**KIRKLEES METROPOLITAN COUNCIL
INVESTMENT & REGENERATION SERVICE**

Reference No:	2026/70/92294/W
Site Address:	36, Scholes Moor Road, Scholes, Holmfirth, HD9 1SJ
Description:	Variation of condition 2 (plans and specifications) on previous permission 2025/92201 for erection of single and two storey rear extensions, single storey front extension and associated alterations
Recommending Officer:	Joshua Merriman

Officer Report – 2026/92294

South West Elevation (side)

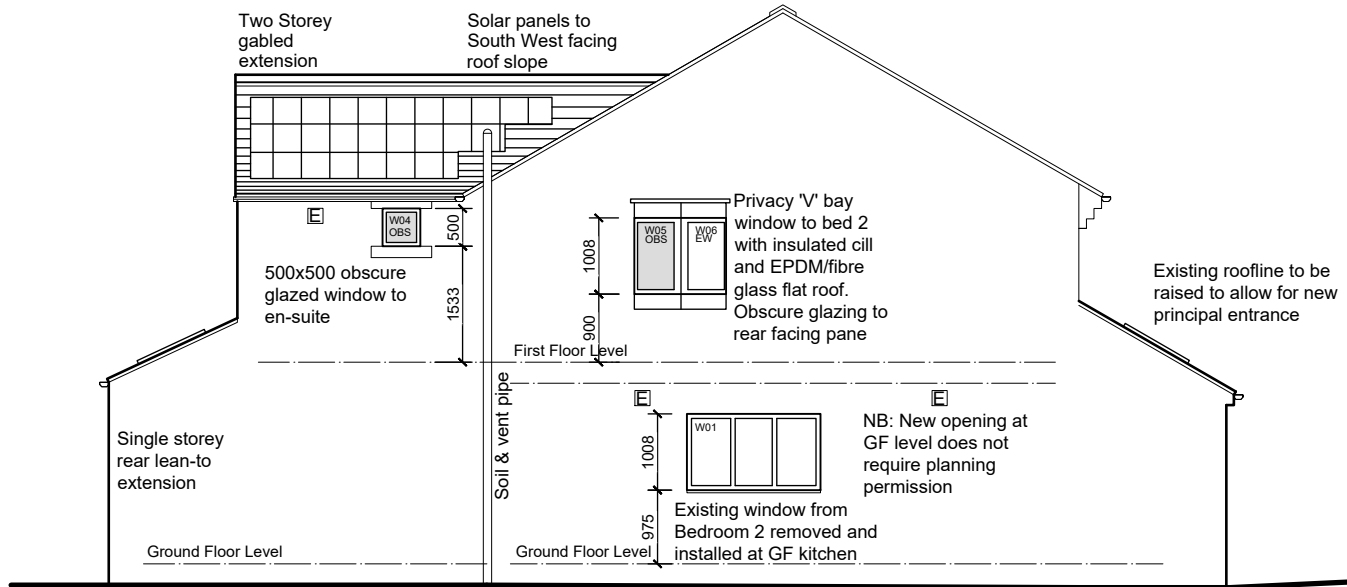
- Replacement of the approved V-shaped first floor window in the South West elevation with a high-level window.
- Reducing the ground floor window in the South West elevation from three panels wide to two panels wide.

The proposed openings in the South West elevation of the dwelling maintain the same distance previously approved from neighbouring dwellings, and are reduced in scale. However, it is noted that there are land level differences between the application property and neighbouring dwelling which has a direct relationship, leading to the rear facing pane of the existing approved window being obscured in the previous application. As a result, it is considered that the high-level window proposed should also be obscured as to prevent direct overlooking into openings within the side elevation of the neighbouring property. This will be secured via condition.

- Window would be at eye level.
- Privacy impact as a result of the proposal particularly due to differing land levels.

- Amended proposal does not specify use of obscure glazing.

Officer Comment: The window has been conditioned as obscure glazed to ensure no overlooking or privacy impacts.

Officer Comment: This has been recommended for inclusion as a condition.

3. In the event the high level window in the South West elevation detailed upon submitted drawing titled 'Proposed South West Elevation' received on 17/08/2026 is to be installed, it shall be fitted with obscure glazing or permanently affixed film which achieves an obscurity of Pilkington level of four or equivalent. Notwithstanding the provisions of the Town and Country Planning (General Permitted Development) Order 2015 as amended (or any Order revoking or re-enacting that Order) the obscure glazing or permanently affixed film shall thereafter be retained for the lifetime of the development..
